NSW RURAL FIRE SERVICE

Your reference: SSD-9439
Our reference: D19/3248
DA19092720608 GB

**State Significant Development Application (SSD-9439)
New Warnervale Public School - 75 Warnervale Road Warnervale 2259**

Drawing Title
CONTEXT PLAN

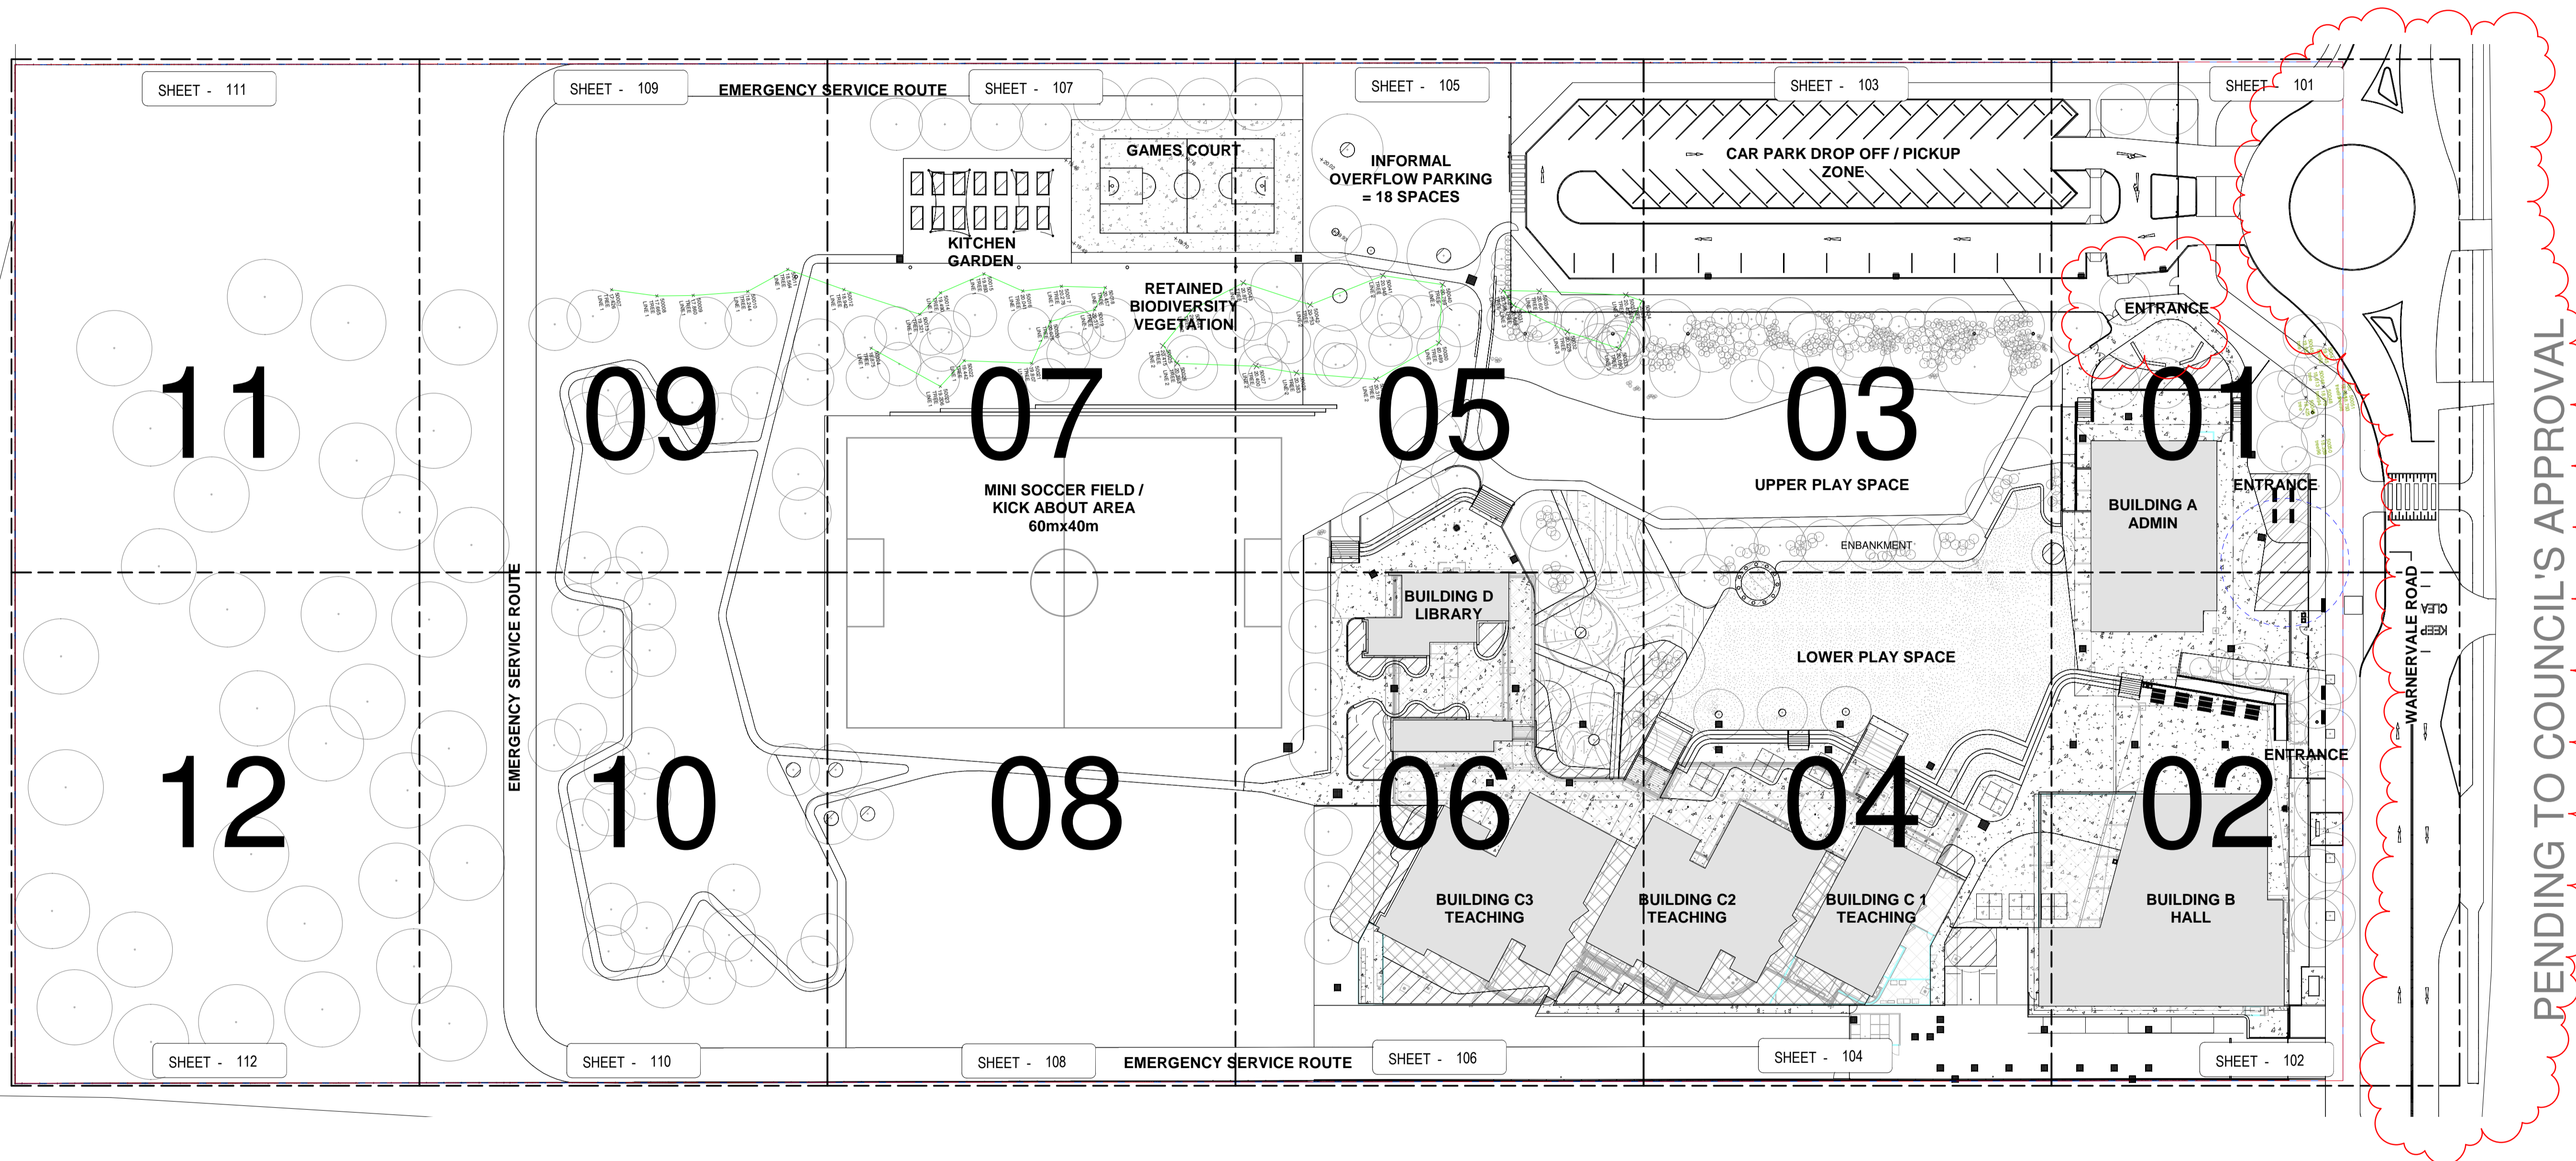
1. At the commencement of building works and in perpetuity, the site boundary setbacks as shown on the Site Context Plan prepared by Billard Leece Partnership, No.AA03-0000, dated 07.08.19., shall be managed as an inner protection area (IPA) as outlined within Appendices 2 & 5 of *Planning for Bush Fire Protection 2006* and the NSW Rural Fire Service's document *Standards for asset protection zones* as follows:

- North: to the property boundary;
 - East: to the property boundary (11m);
 - South: for a minimum distance of 70 metres; and
 - West: for a minimum distance of 70 metres. The Administration & Staff Building – Core 21, may have a reduced setback as shown (approximately 52m to the original side boundary).

2. The provision of water, electricity and gas services shall comply with section 4.2.7 of *Planning for Bush Fire Protection 2006*.
3. The proposed emergency service route shown on the Site Context Plan shall comply with section 4.1.3 (3) of *Planning for Bush Fire Protection 2006* at a minimum.
